Application by National Highways for A47 Wansford to Sutton Dualling

The Examining Authority's further written questions and requests for information (ExQ2)

Issued **5 April 2022**
Deadline **20 April 2022**

LOWER LODGE FARM EXISTING & PROPOSED JOURNEY LENGTHS

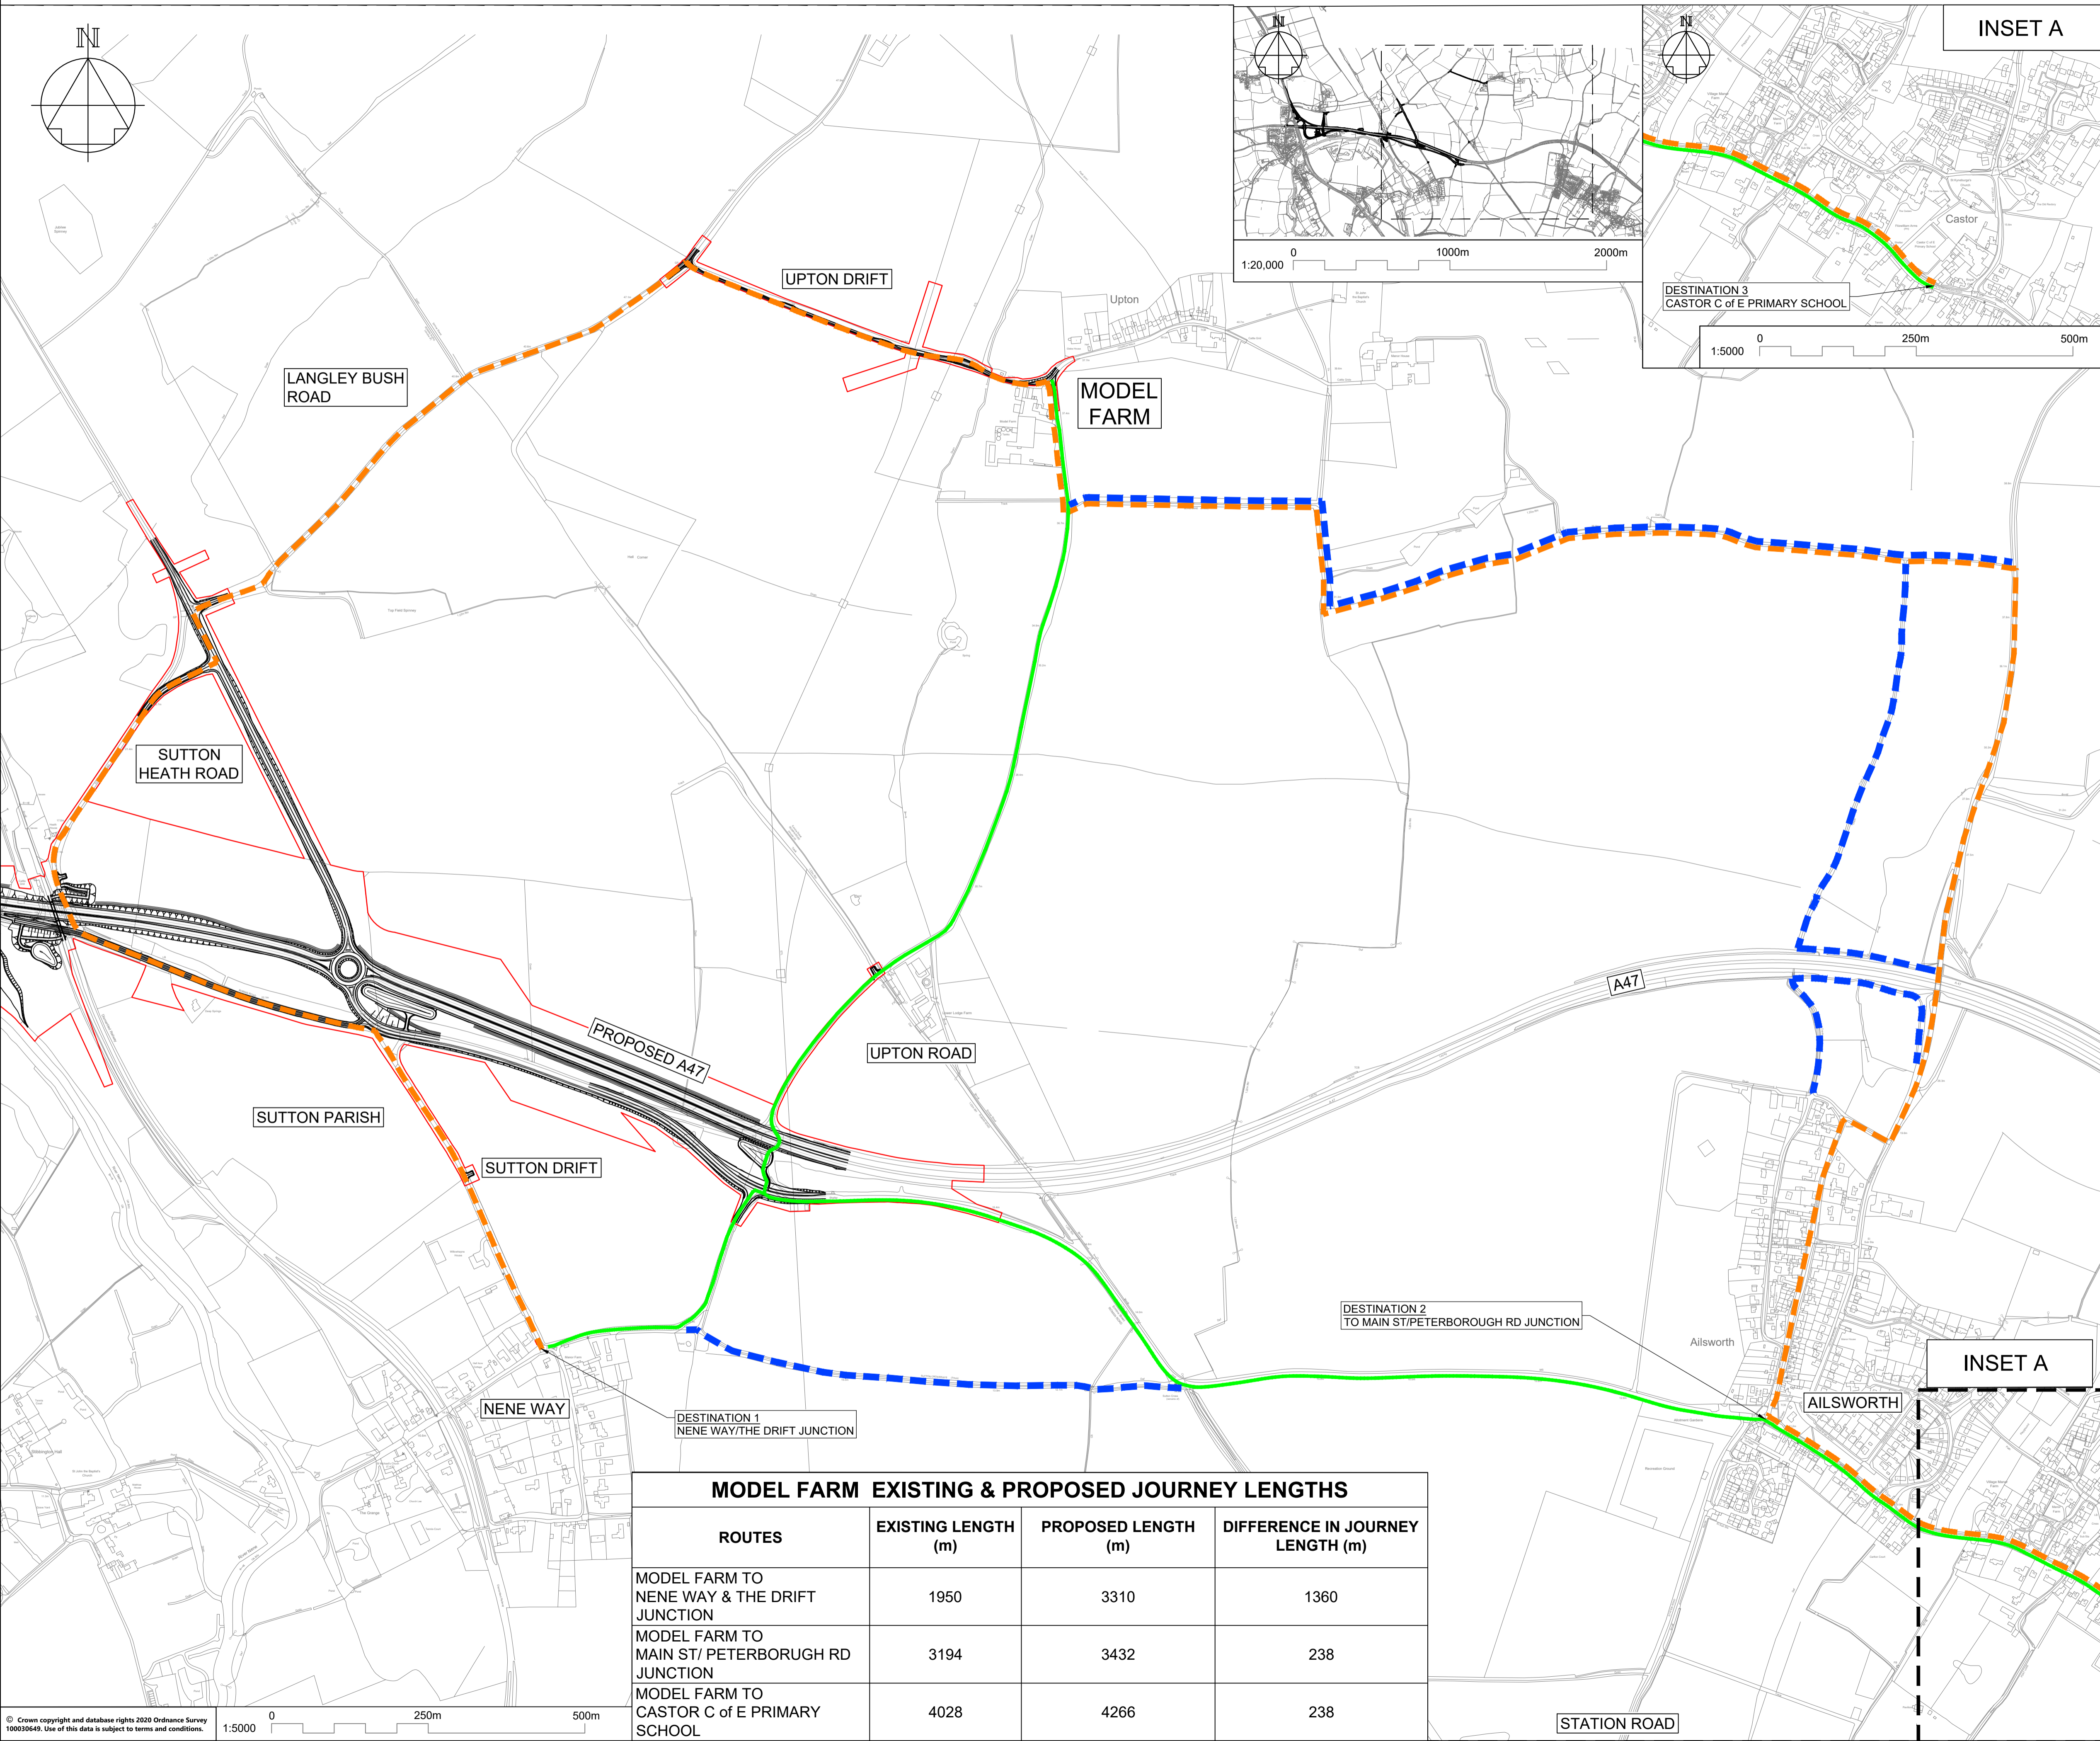
2.11.	Traffic and transport	
2.11.1.	The Applicant	Stopping up of Upton Road south of Lower Lodge Farm The Applicant indicates that alternative provision is to be made via the Wansford NMU underpass. Could the Applicant please set out the distances that a WCH would

ExQ2	Question to:	Question:
		have to travel from Lower Lodge Farm to the existing junction of the A47 with Sutton Heath Road, in both the existing and proposed scenarios. The routes should also be shown on a plan to an Ordnance Survey base.
